From: Laura Gibbons
Sent: 24 October 2018 16:04
To: Planning.Responses
Cc: Simon Davis
Subject: RE: Planning Consultation on: EG/67/18/HH

Engineers Comments Regarding Surface Water Drainage

APPLICATION EG/67/18/HH

Site Address: Trebarwith Cottage Barnham Road Eastergate PO20 3RS

SITE PLAN SCALE 1:200

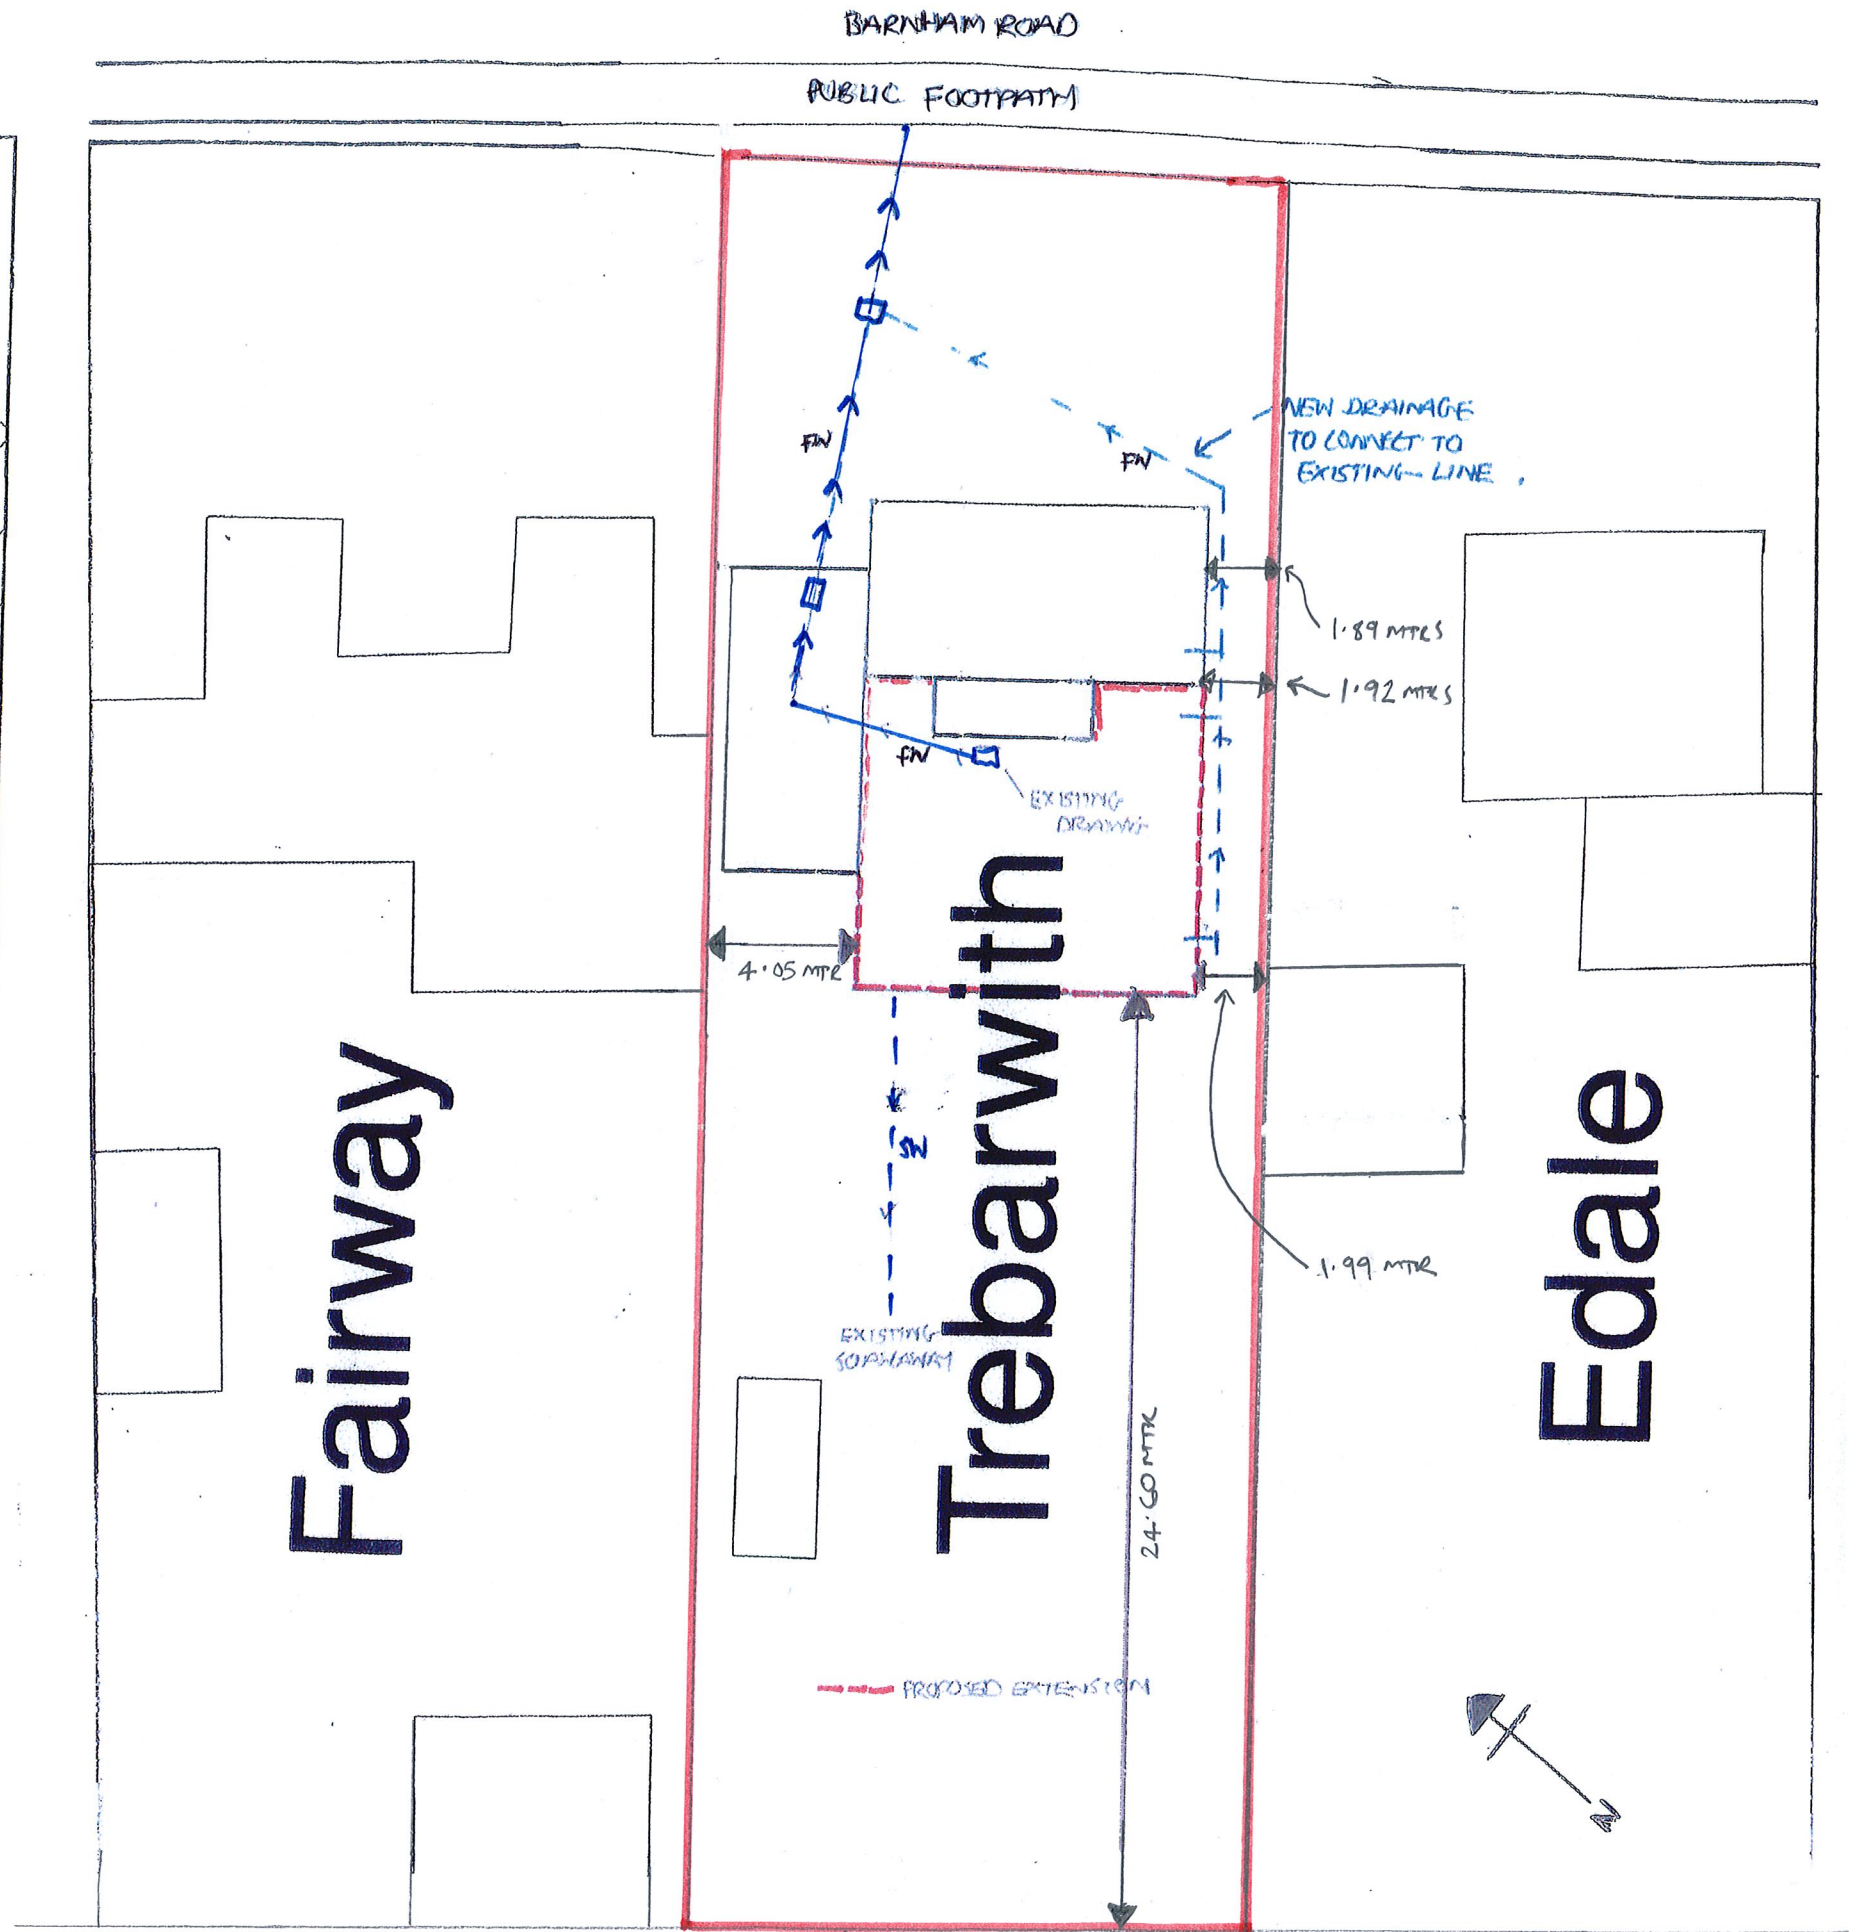
The application seems to detail that the surface water will be disposed of to the existing soakaway, this will not be suitable because: the roof area is to substantially be increased; old drainage requirements for surface water drainage were far less than modern standards; existing soakaway condition is unknown.

Soakaways must be investigated for surface water disposal.

Infiltration rates for soakage structures are to be based on percolation tests undertaken in the winter period and at the location and depth of the proposed structures. The percolation tests must be carried out in accordance with BRE 365, CIRIA R156 or a similar approved method and cater for the 1 in 10 year storm between the invert of the entry pipe to the soakaway, and the base of the structure. It must also have provision to ensure that there is capacity in the system to contain below ground level the 1 in 100 year event plus 40% on stored volumes, as an allowance for climate change. Adequate freeboard must be provided between the base of the soakaway structure and the highest recorded annual groundwater level identified in that location.

Any SuDS or soakaway design must include adequate groundwater monitoring data to determine the highest winter groundwater table in support of the design. The applicant is advised to discuss the extent of groundwater monitoring with the Council's Engineers. Supplementary guidance notes are also enclosed for information.
